REQUEST

Current Zoning: N1-A (neighborhood 1, A)
Proposed Zoning: N1-E (neighborhood 1, E, conditional)

Approximately 1.988 acres located at the deadend of Pickway Drive, west of North Graham Street.

The petition proposes to develop two duplex buildings and two triplex buildings on parcels that are mostly vacant with one single family home.

**PICKWAY TOWNHOMES (2023-095)**  
REZONING SITE LAYOUT PLAN  
2541 PICKWAY DRIVE, CHARLOTTE, NC  
MEN IN MOTION, LLC  
PROJECT NO. 23006  
PROJECT MANAGER: KYU

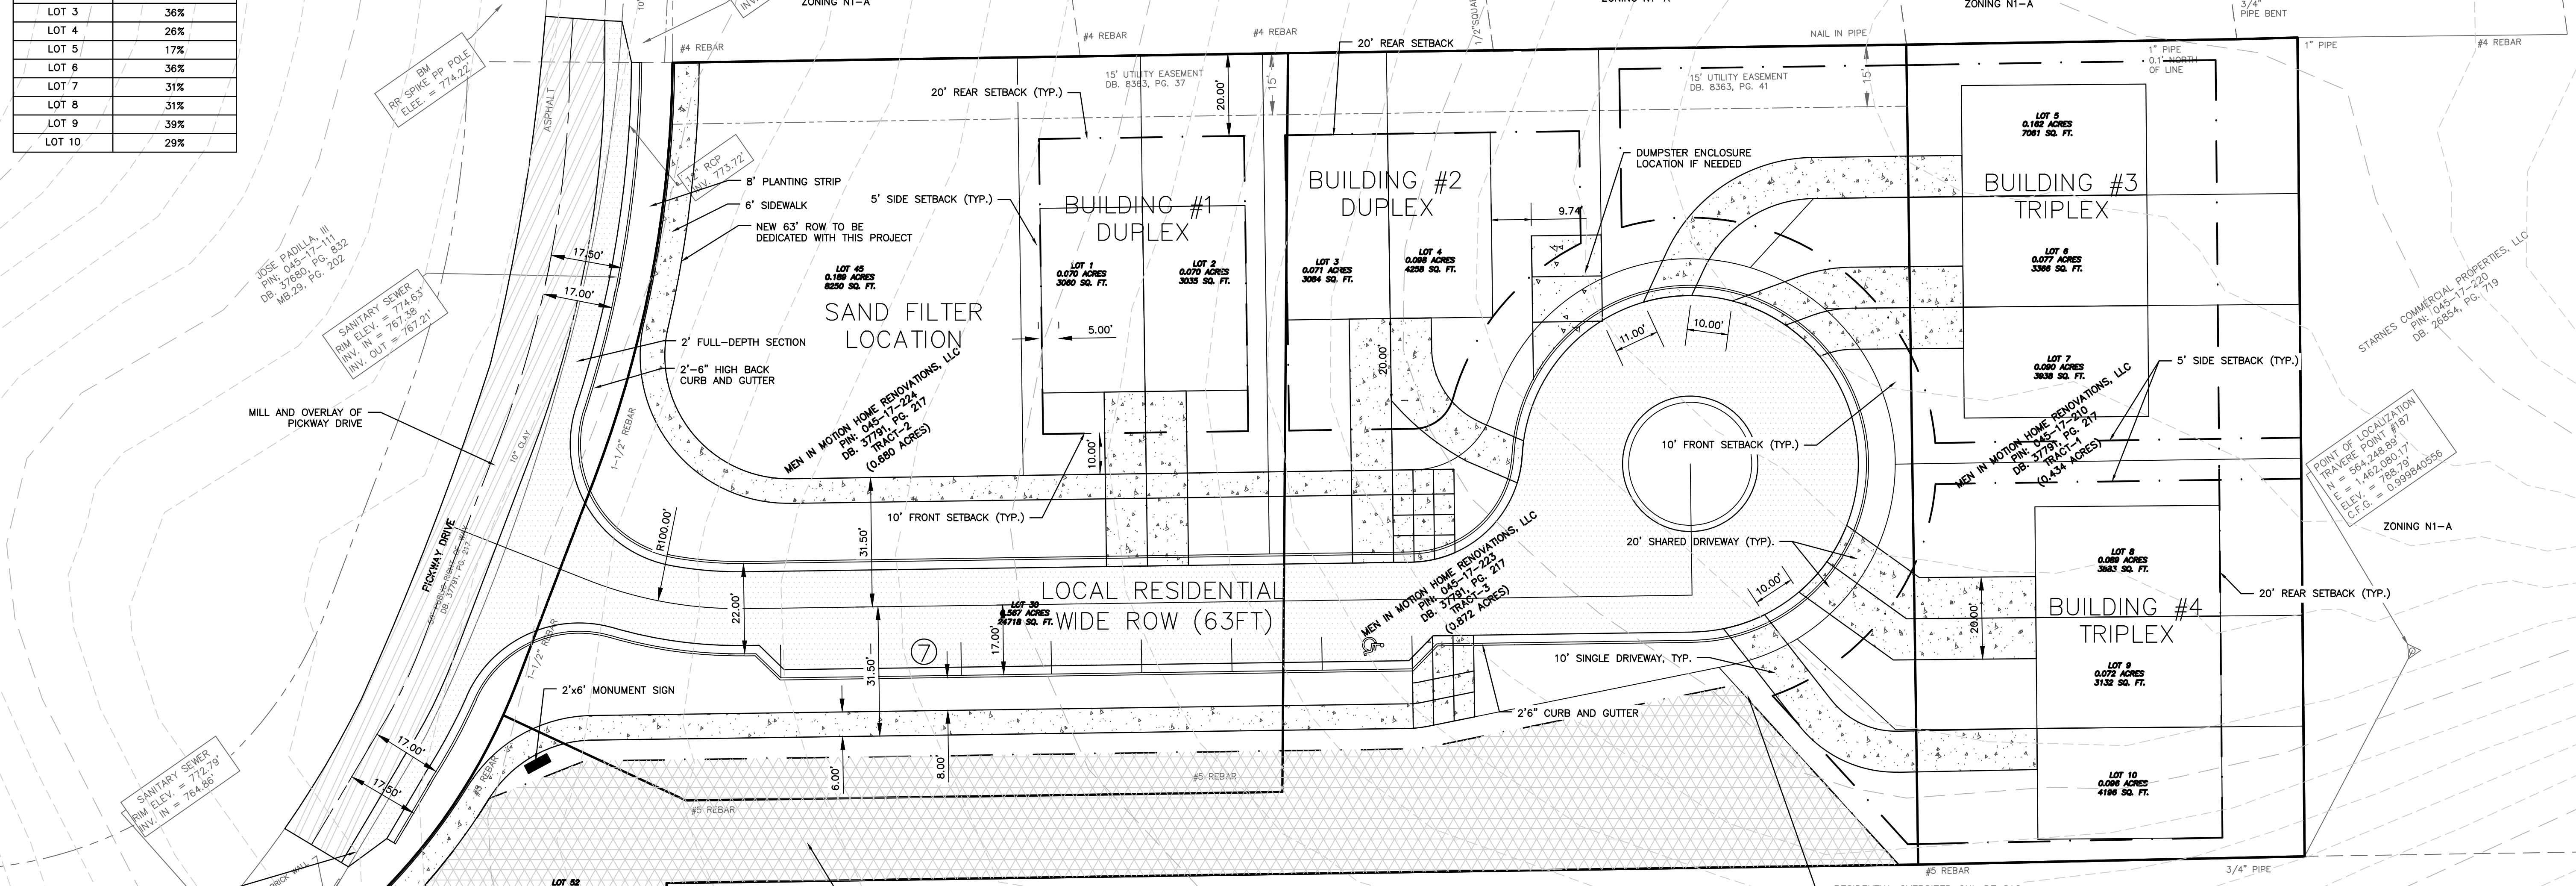
1. Revise site plan and conditional notes to commit to dedicate 31.5 feet of right-of-way from the road centerline. Label and dimension the right-of-way from the road centerline on the site plan.
2. Revise conditional notes to commit to an 8' planting strip and 6' sidewalk per the CLDSM U-03A2 along Pickway Drive per UDO Article 33. The sidewalk should extend across the entire frontage, including at the intersection of the proposed public street and Pickway Drive as well as fully to property line.
3. Revise conditional notes to commit to milling and overlaying the entire section of Pickway Drive across the development frontage.

4. Specify planting standards in the rear setback against PID 04517220. Consider adding conditional notes for planting standards that mirror the standards outlined for Class B or Class C Landscape Yards. Add a 6' opaque wooden fence along the site's boundary against PID 04517220.
5. Add a 6' opaque wooden fence along the site's boundary against PID 04517209.

6. Correct the listed zoning of PID 045-172-20 to ML-1.

7. Clearly distinguish and label each building as being on its own lot. Sublots for the individual units should be distinguished by dashed lines.
